Ref: 17165-Waitara-BCAReportR3-201217R2

WAITARA PUBLIC SCHOOL

**BUILDING CODE OF AUSTRALIA 2016
FINAL DA STAGE REVIEW**

DECEMBER 2017

A SECTION
DA-AR-2000 SCALE 1:100

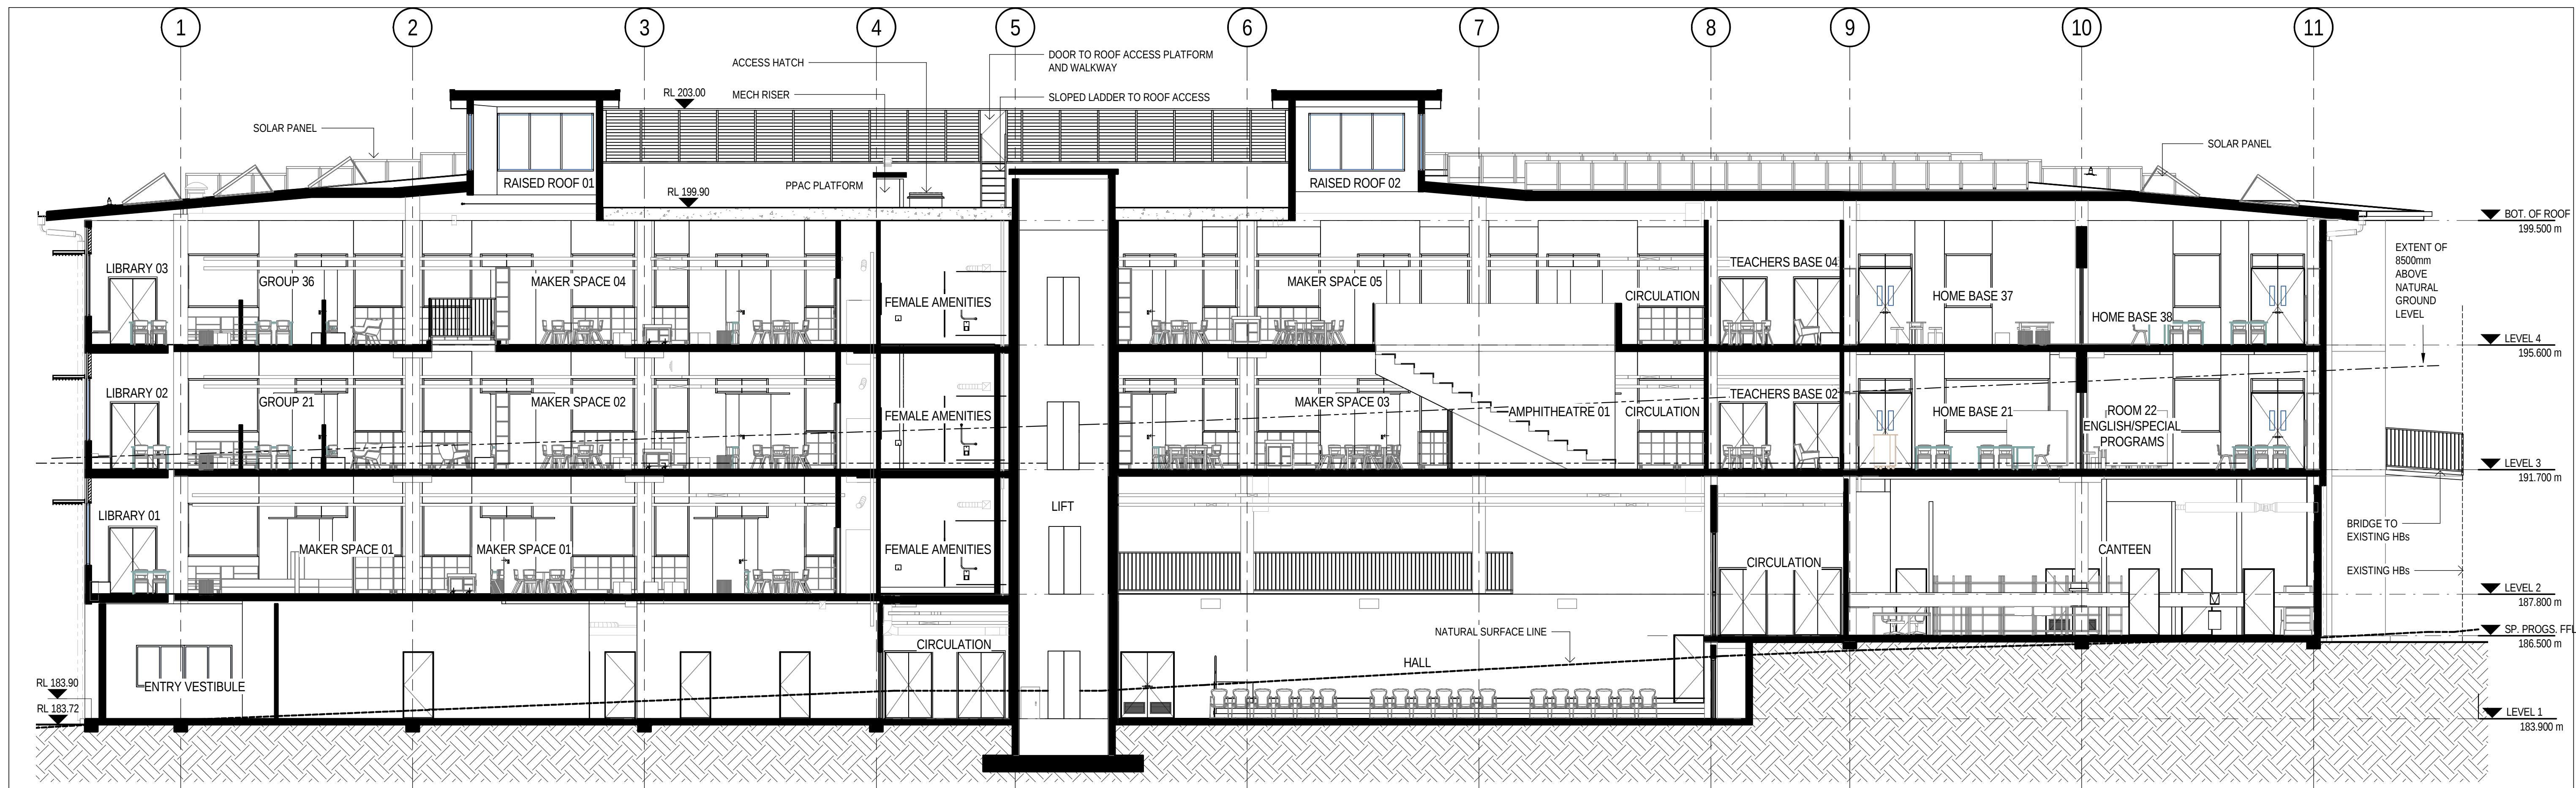
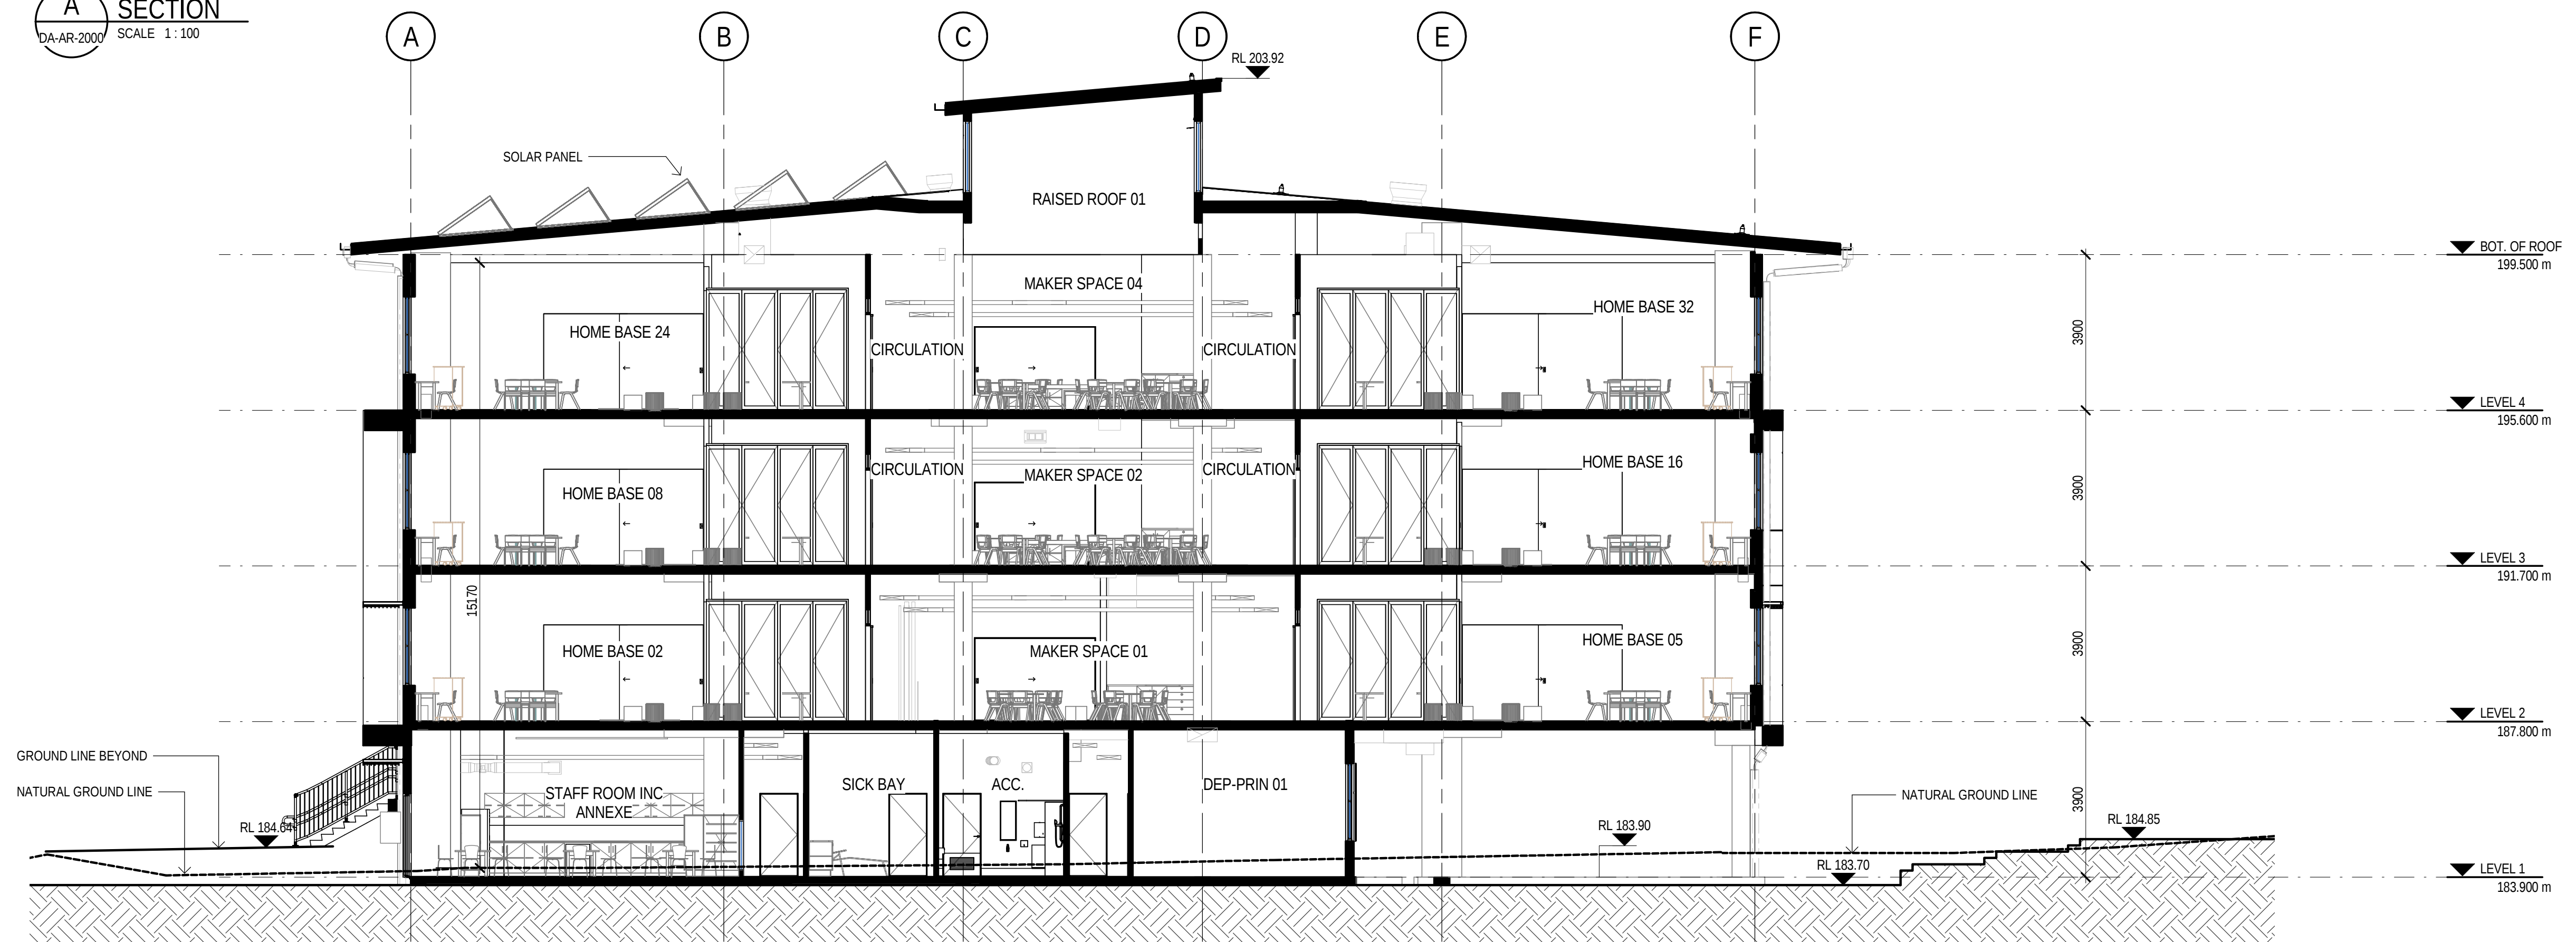
The travel distance from the corner of the homebase 30 on level 4 will have to be reassessed after the furniture plans are provided for review to ensure that the point of choice is within 20m of the starting point. It is expected that egress will be provided from level 3 through the foyer and into the adjoining building.

The exits serving level 1, 2 and 3 are not distributed as uniformly as practicable within the storey as they are only located on the northern side of the floor plate. At least one fire stair should be relocated to the southern side of the floor or the current arrangement should be justified in a fire engineered alternative solution report.
